**Response to Action Points**

**Issue Specific Hearing 7 on the draft Development Consent Order – 23rd October 2019**

(TR010027-000798-DCO4 Action Points 23 October V2)

Drawing Title  
**REVISED ACCESS ARRANGEMENTS FOR FOUR WINDS AND GAA**

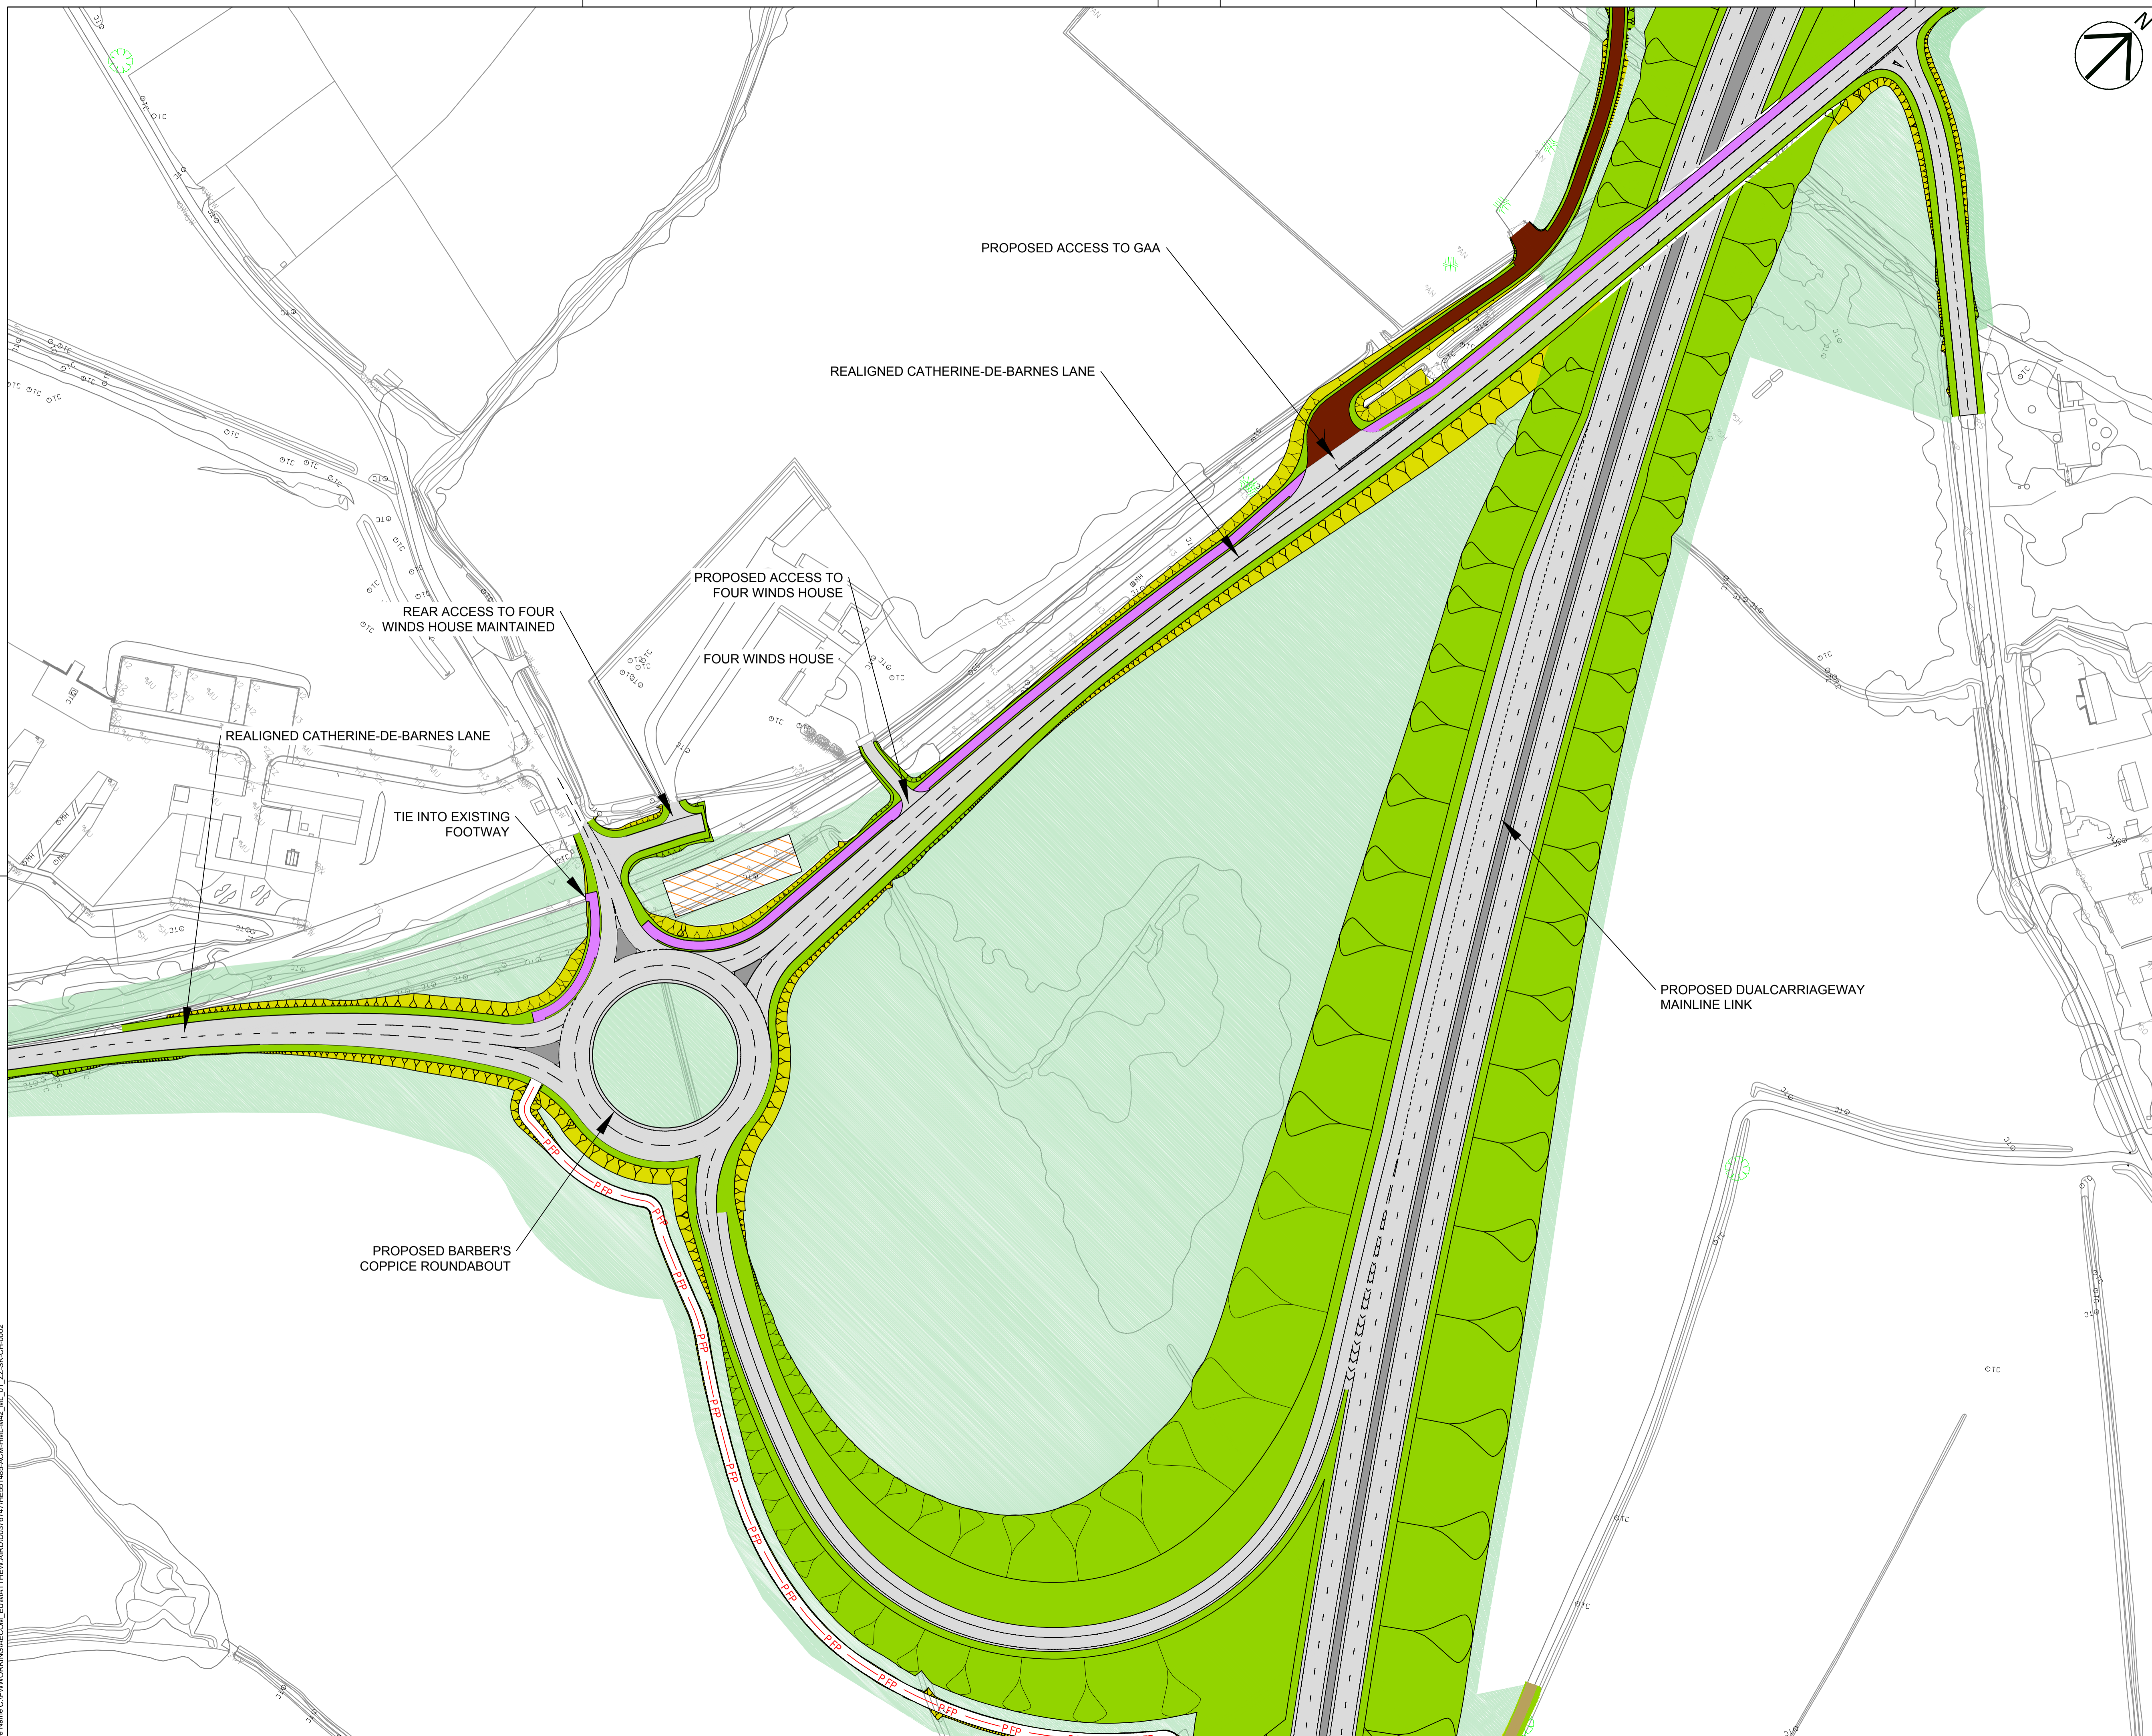
- The letter does not contain any information on what visual screening will be provided between my property and the Mainline Link road / Slip Road from Barber's Coppice.

- Any fencing or boundary treatment to my property will be behind an area of 'environmental mitigation' but no details on what that means or the extent of the planting have been provided.

- If the 'environmental mitigation' outside my property consists solely of native hedge planting it will provide seasonal cover only.
- The land between the centre line of the existing Catherine de Barnes Lane (which I assume will be my new boundary under ad medium filum) and the realigned Catherine de Barnes Lane will be 25m wide but Highways England are unable to confirm if it will all be planted out. Needless to say, leaving large areas of grass verge is not an ideal solution in this location.

- Proposed boundary treatments do not include any options for noise mitigation, particularly around the proposed 'Barber's Coppice Roundabout'.
- No details on fencing specification such as dimensions, material, finish, etc. have been provided. One would expect the specification to provide a minimum lifespan of 30 years, not require painting (other than preservative treatment) and given our existing timber fencing is Oak any new fencing should ideally match.
